# **OXFORDSHIRE COUNTY COUNCIL'S RESPONSE TO CONSULTATION ON THE FOLLOWING DEVELOPMENT PROPOSAL**

**Application no:** 14/02121/OUT-3

**Location:** Proposed Himley Village North West Bicester Middleton Stoney Road Bicester Oxfordshire

### **1) OCC response to Himley Village submission of 21 December 2016**

75 Cowcross Street London EC1M 6EL  
tel 020 7250 1555  
email aba@alanbaxter.co.uk

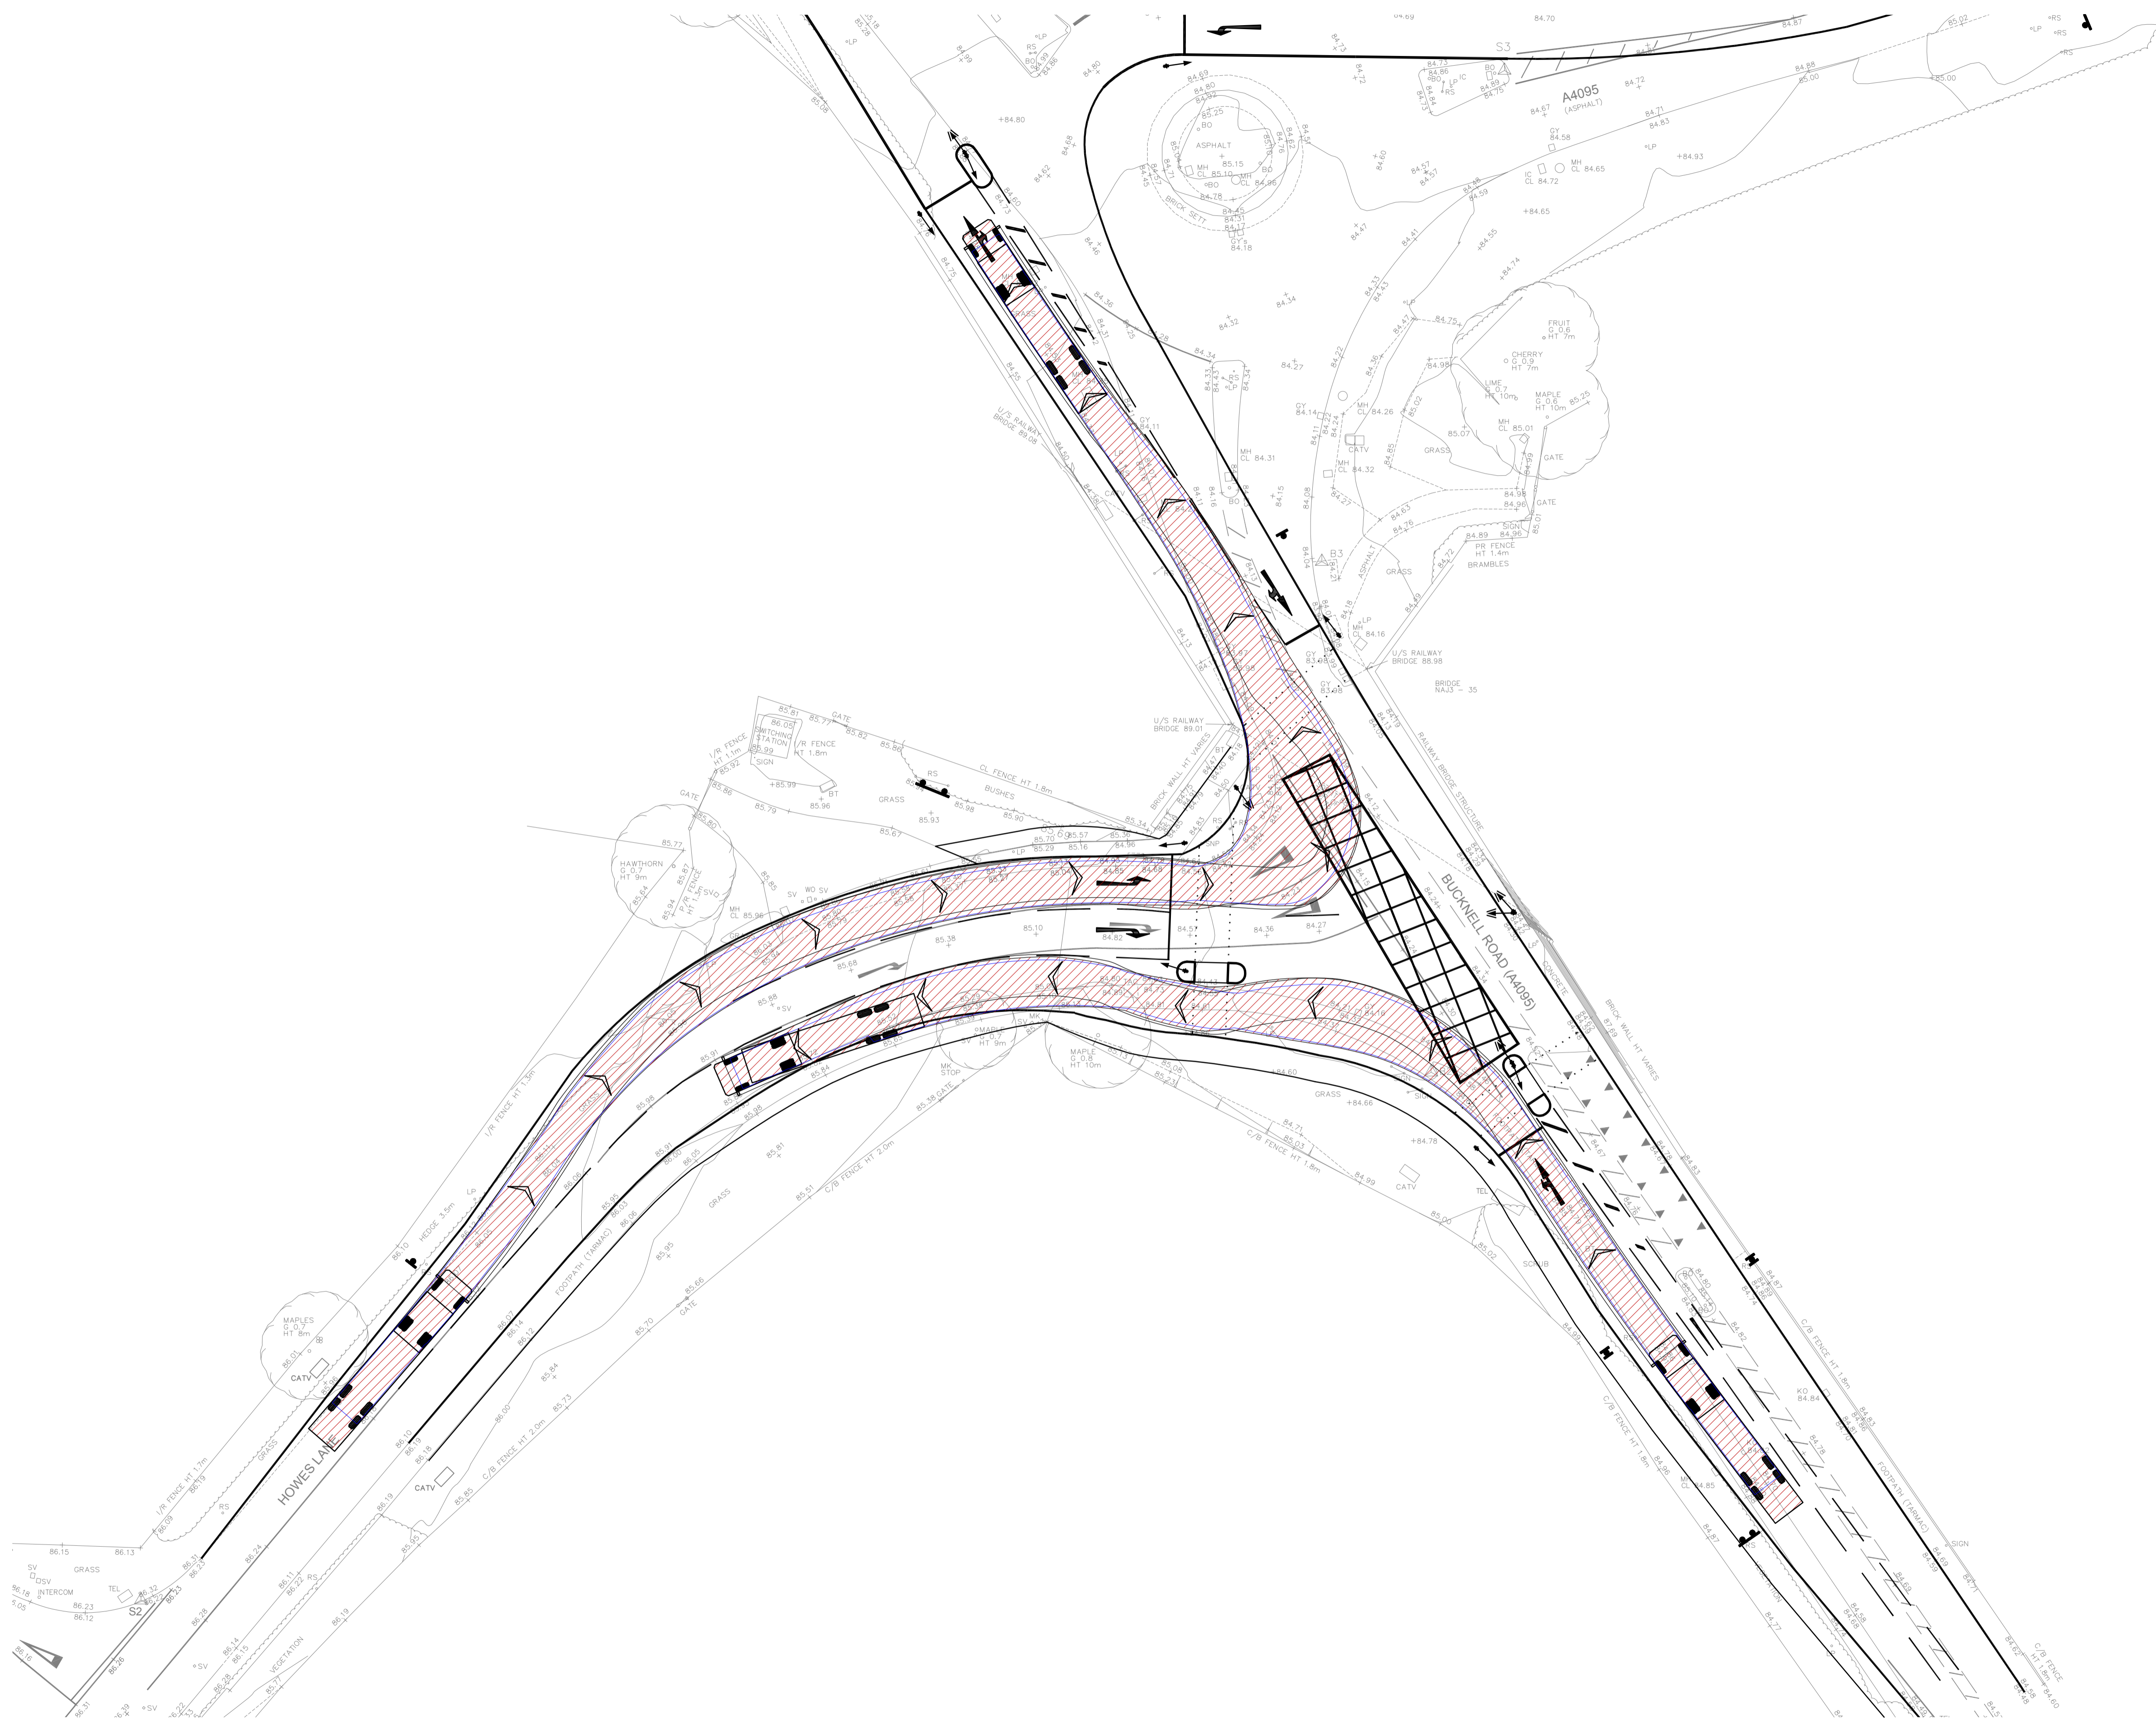
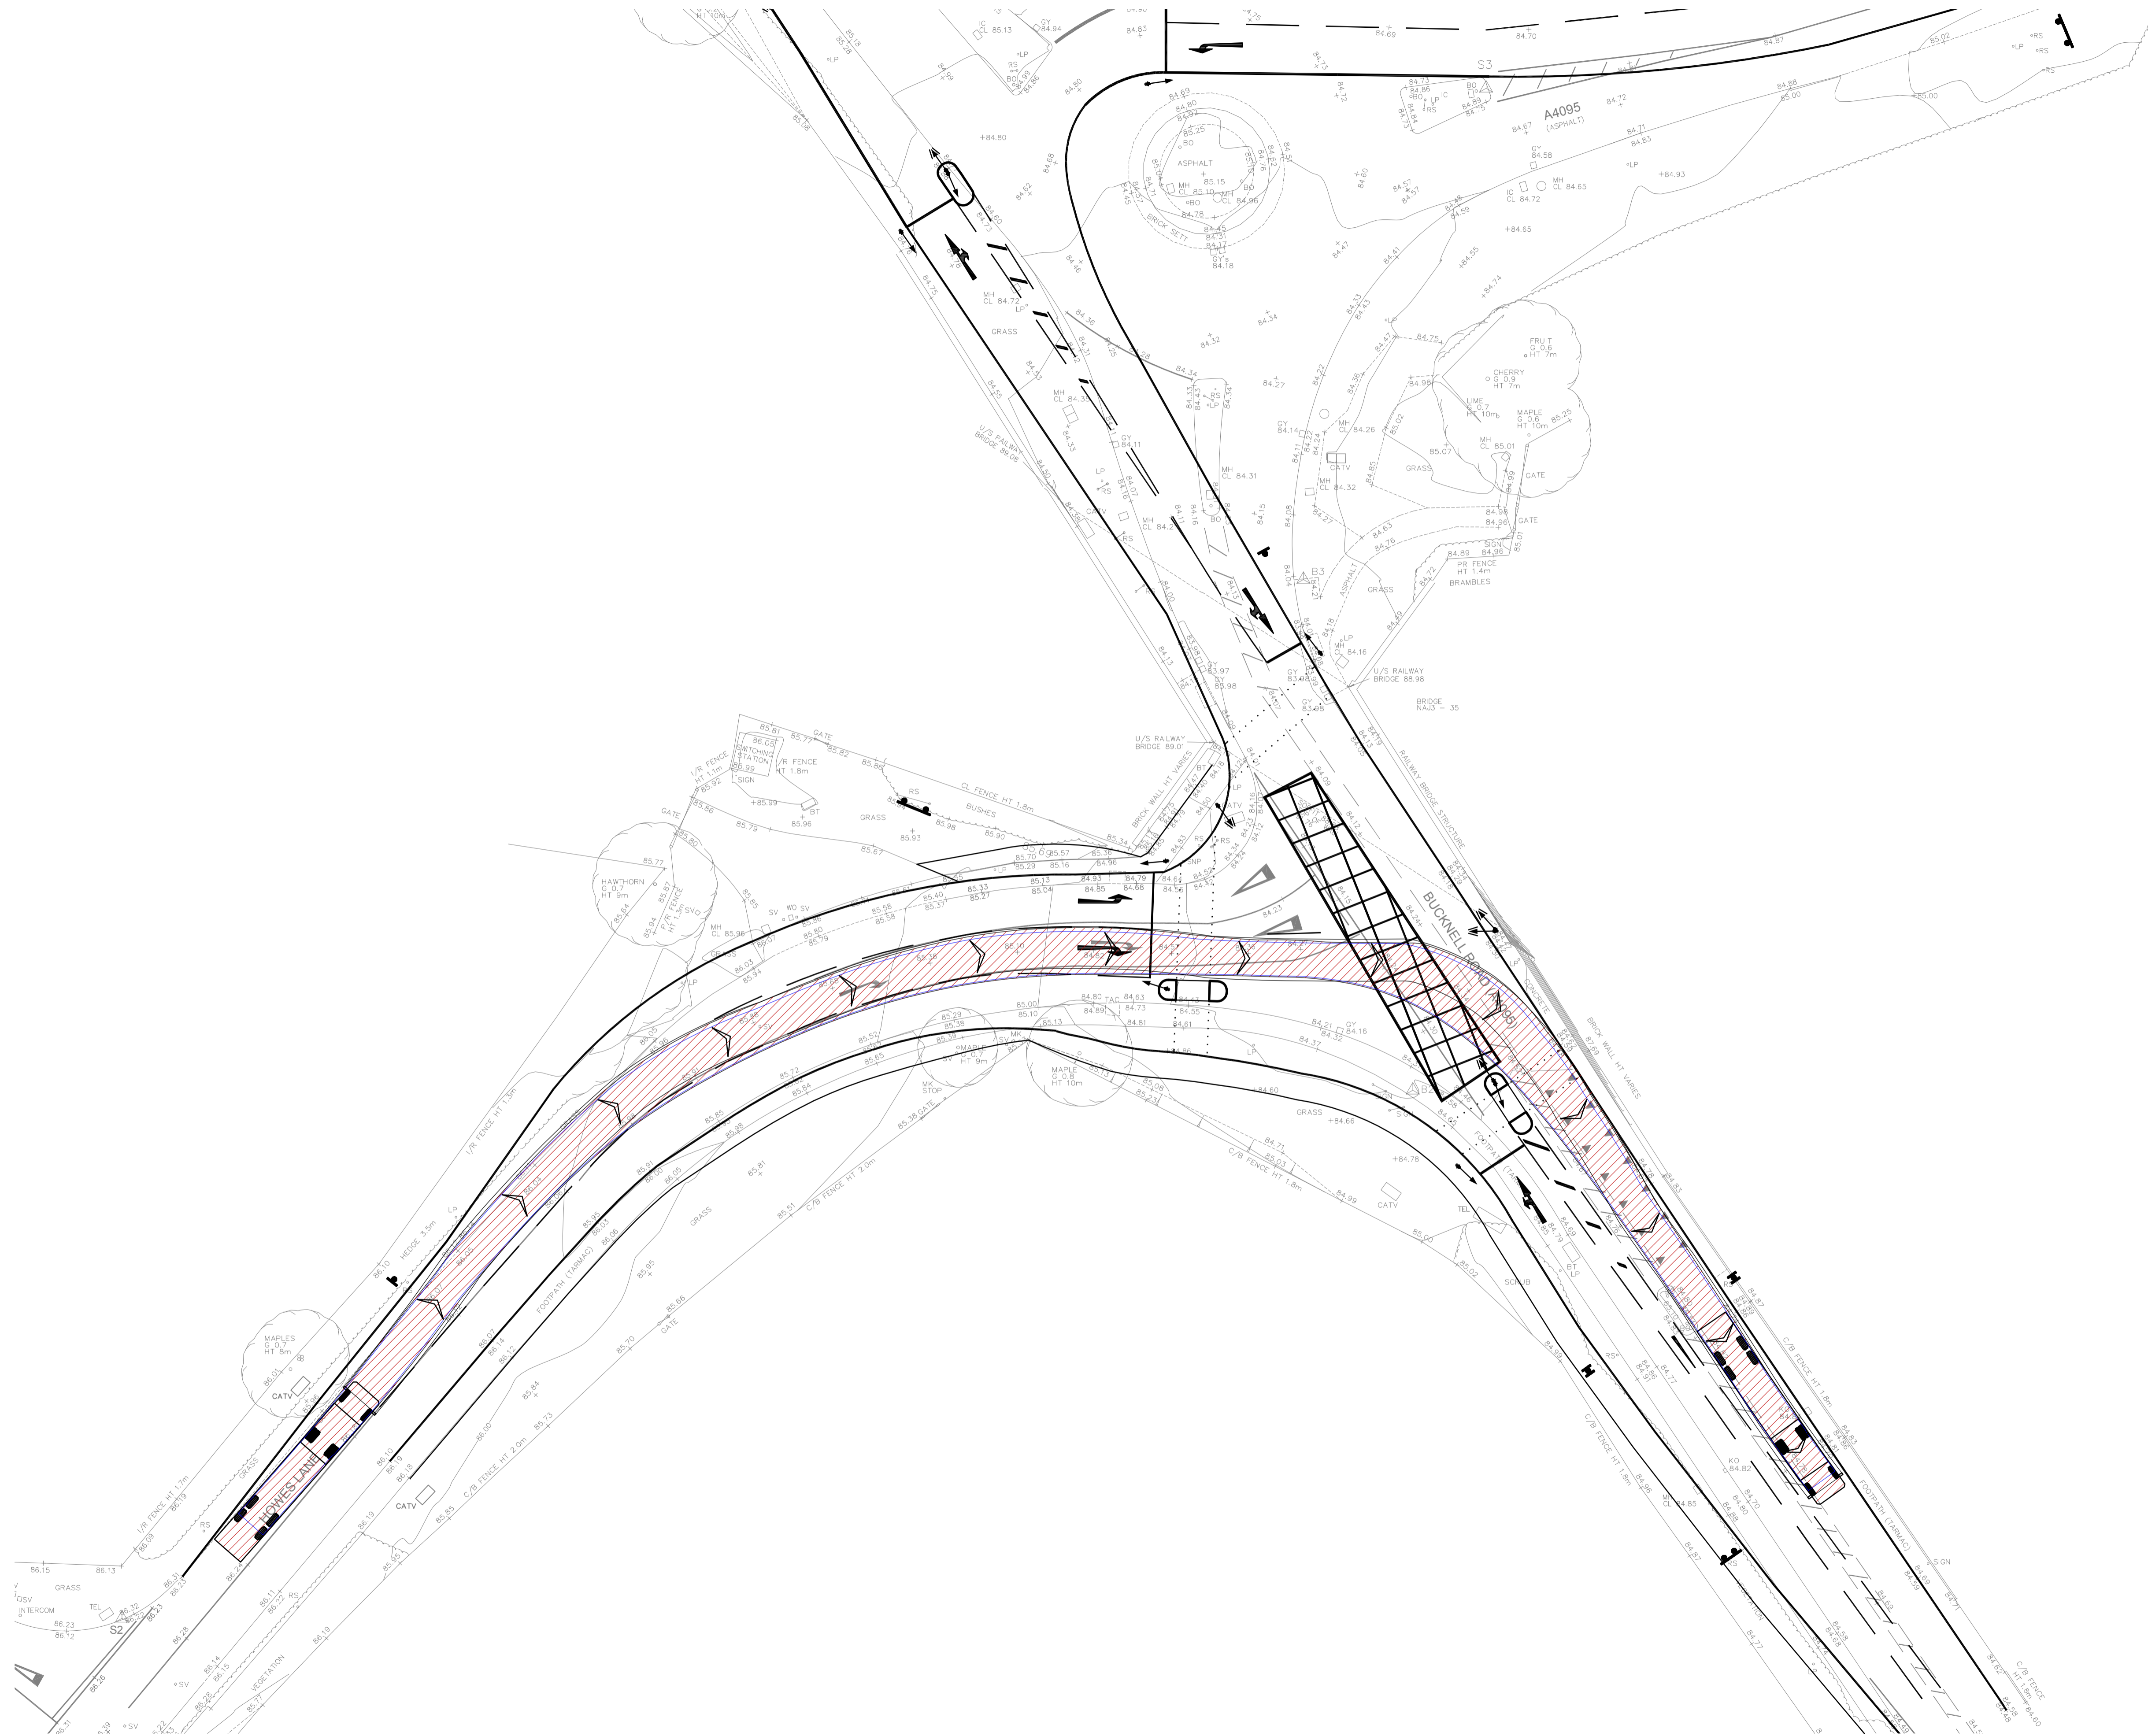
OCC maintains its objection to the proposed interim scheme because the submission does not demonstrate that previously identified problems can be remedied. Rather it states that these issues can be addressed at S278 application stage. The professional opinion of OCC engineers is that space at the junction is so constrained that it will not be possible to address the concerns and produce a design that will satisfy technical and safety audit, and that, as a result the scheme is not feasible. A full critique of the issues raised in the Technical Note is set out in Table 1 below.

Concern raised in OCC response of 15 Dec	Alan Baxter/PCL response to our concern	OCC response
Pinch Point on Howes Lane	<ul style="list-style-type: none"> <li>• Very low usage by pedestrians and cyclists during the hour surveyed therefore can assume low usage throughout the day and therefore very low risk of conflict.</li> <li>• Cyclist use of the footway is illegal anyway and the proposed scheme means they would be less likely to use the footway</li> <li>• Footway widths of no less than 1m at pinchpoints can be confirmed at next iteration of design (S278 application)</li> </ul>	<p>PCL, as part of the safety audit of the existing conditions carried out for Alan Baxter, did a ped/cycle count between 0740 and 0840 on Thurs 15 Dec. 2 peds and 3 cyclists were observed using the footway on the SE corner of the Bucknell Rd/Howes Lane jct.</p> <p>I would argue that this hour is not representative as it would not cover all people walking to work at the employment site and it is also unlikely to be representative of leisure users of the bridleway.</p> <p>In any case, I reiterate that even if pedestrian use is low, this does not remove the risk, either of collisions between peds or peds and cycles, or of peds/cycles being swiped by passing vehicle overhangs.</p>

<ul style="list-style-type: none"> <li>• Vulnerability of pedestrians given proximity to turning HGVs is noted but risk is discounted due to low number of pedestrians. PCL recommends widening footway to overcome this.</li> <li>• Suggestion that adherence to Inclusive Mobility guidelines is not required because people with mobility issues are unlikely to be using the footway here: 'people with mobility issues tend to undertake short journeys with a specific destination'</li> <li>• Footway extension on north side of Howes Lane could remove the problem provided sufficient widths can be maintained around street furniture. Recommendation to extend footway to Police Training Centre</li> <li>• Proposal of an option to look at relocating the central refuge on Howes Lane to provide additional footway width, and to carry out ped/cycle surveys during peak hours and weekends, for 'further development and finalisation of the junction design'</li> </ul>	<p>I also reiterate that, given the knowledge that cyclists use the footway, this must be taken into account. It cannot be concluded that cyclists would be less likely to use the footway in the proposed scheme. The Alan Baxter note says that 'experienced and confident cyclists (who are more likely to be on the carriageway than the footway) will position themselves so that they are close to the middle of the lane with vehicles following behind them' making it '...relatively easy for them to move across to the right hand lane on approach to the signals.' This reinforces my point, because the <u>less</u> confident cyclists are still likely to use the footway, as well as ones trying to avoid the queues. The provision of advanced stop lines would have little benefit as there is insufficient space to provide a lane leading into them, so cyclists would not be able to get to the front of the queue to enter the ASL box.</p> <p>I strongly refute the suggestion that people with mobility issues should not necessarily be catered for in this scheme, for reasons of inclusivity. In any case there is no basis for the suggestion that this kind of user would not wish to use this route.</p> <p>OCC engineers' professional opinion is that space at the junction is so constrained, that sufficient footway widths could not be found at the next iteration of the design, and that the scheme would not be deliverable as it would not pass its technical/safety audit.</p> <p>The footway on the northern side of Howes Lane would be welcomed if there is sufficient space. However, the applicant has not demonstrated that this is feasible. Even though it would make the footway on the south side largely redundant, the</p>

<p>distance from the kerb to the garden fence on the south side could not be reduced further, as sufficient verge is required for maintenance.</p>
<p>Crossing point on Bucknell Rd between Howes Lane and Lords Lane</p>	<ul style="list-style-type: none"> <li>• Proposals provide better visibility between pedestrians waiting to cross and vehicles turning left out of Howes Lane, as well as better awareness of pedestrians under signalisation, in the proposed scheme compared with the current situation.</li> <li>• Signalisation improves the opportunities for crossing safely here, even without a pedestrian phase, and also increases the predictability of vehicle movements, allowing regular users to learn when in the traffic signal phasing, it is safe to cross.</li> <li>• Proposal of an option to consider a pedestrian phase on the assumption that it would not be called every cycle (and therefore may not impact on capacity).</li> </ul>	<p>CPL has carried out a Stage 3 safety audit for Alan Baxter, of the existing arrangements. Please see discussion of that safety audit below as we do not accept its findings and it does not agree with the independent safety audit carried out for the recent mitigation scheme at the junction.</p> <p>The predictability argument is not conclusive, but even if I was prepared to concede this point, we still have significant concerns about this crossing point. The crossing point is at a pinch point where the tactiles would be only 0.7m wide (between the kerb and the bridge abutment wall) at their northern point, and vehicle tracking is extremely close to the kerb.</p> <p>Also, on rechecking the drawings, the intervisibility zone is well below DMRB standard (and here I have to correct my previous comment that the intervisibility was adequate) due to the major obstruction of the bridge wall. Whilst there is intervisibility between the stop line on Howes Lane and the crossing point, DMRB requires intervisibility between points 2.5m back from the stop line extended across the carriageway, which the proposed scheme does not provide for, so it does not meet standards.</p> <p>There is a risk that the change to the kerblines could make it easier for vehicles to take the left turn faster than at present. On a green signal, drivers will not hesitate in order to give way to traffic from the right, and may in fact accelerate up to the traffic signals and take the corner quickly, in order not to miss the</p>

<p>green signal, putting pedestrians at risk. Having less than standard intervisibility due to the bridge wall may well exacerbate this risk.</p> <p>Intervisibility between points behind the stop line is primarily required to cater for instances when traffic signals fail and drivers need to see when it is safe to proceed. The fact that the scheme does not meet the standard could well be a reason that a S278 agreement cannot be reached.</p> <p>In terms of pedestrian safety, pedestrian phases would be welcomed, but would have the potential to reduce the capacity of the junction and would need to be modelled. The assumptions regarding frequency of call only once every 7.5 cycles would need to be tested against surveys with pedestrian demand growthed up in line with traffic growth. This would then need to be demonstrated through updating the LinSig model.</p>
Signal equipment and traffic signs		<p>We are agreed that there are likely to be ways of accommodating signage and traffic signals so as not to create an obstruction on the footways but this would need to be demonstrated.</p>

Vehicle tracking	<ul style="list-style-type: none"> <li>Proposals are an improvement on current situation.</li> <li>There is scope to refine the design 'to accommodate instances where swept paths show vehicles crossing the centre line and coming close to the kerb line'</li> <li>Combination of low ped and HGV use means low risk of</li> </ul>	<p>CPL has carried out a Stage 3 safety audit for Alan Baxter, of the existing arrangements. Please see discussion of that safety audit below as we do not accept its findings and it does not agree with the independent safety audit carried out for the recent mitigation scheme at the junction.</p> <p>OCC engineers' professional opinion is that space at the junction is so constrained, that there is no scope to widen the carriageway to address tracking issues, without reducing the footways unacceptably.</p>

<p>conflict in comparison to existing situation.</p> <ul style="list-style-type: none"> <li>• Design of central refuge is in accordance with current guidance.</li> <li>• Swept path in any case provides a margin of safety.</li> <li>• Containment kerbs may be used to prevent damage to structures.</li> </ul>	<p>I do not understand the statement that the swept path provides a margin of safety. It is based on the actual vehicle widths of the design vehicles including their wing mirrors. The notes on the swept path drawings state:  <i>'The computer programme assumes an 'optimum vehicle' in terms of performance and driver ability and hence additional areas for unrestricted movement may be required.'</i></p> <p>Whilst it is acknowledged that the refuges would be of benefit to pedestrians, they result in very tight tracking which would only be achieved by an 'optimum vehicle', implying that in practice the situation could be worse than shown in the drawings.</p> <p>HGV use of the junction will inevitably increase as a result of construction and development around Bicester. Pedestrian use of the junction will increase in proportion with general traffic growth. This means the frequency of potential conflict will increase.</p> <p>It is acknowledged that the refuges are 1.5m wide and therefore in accordance with current guidance in this respect.</p> <p>The use of containment kerbs as satisfactory to prevent damage to the bridge structure, given that the kerb would move to only 700m from the structure, has not been discussed with Network Rail and there is no certainty that this would be accepted by Network Rail at the approval stage.</p>
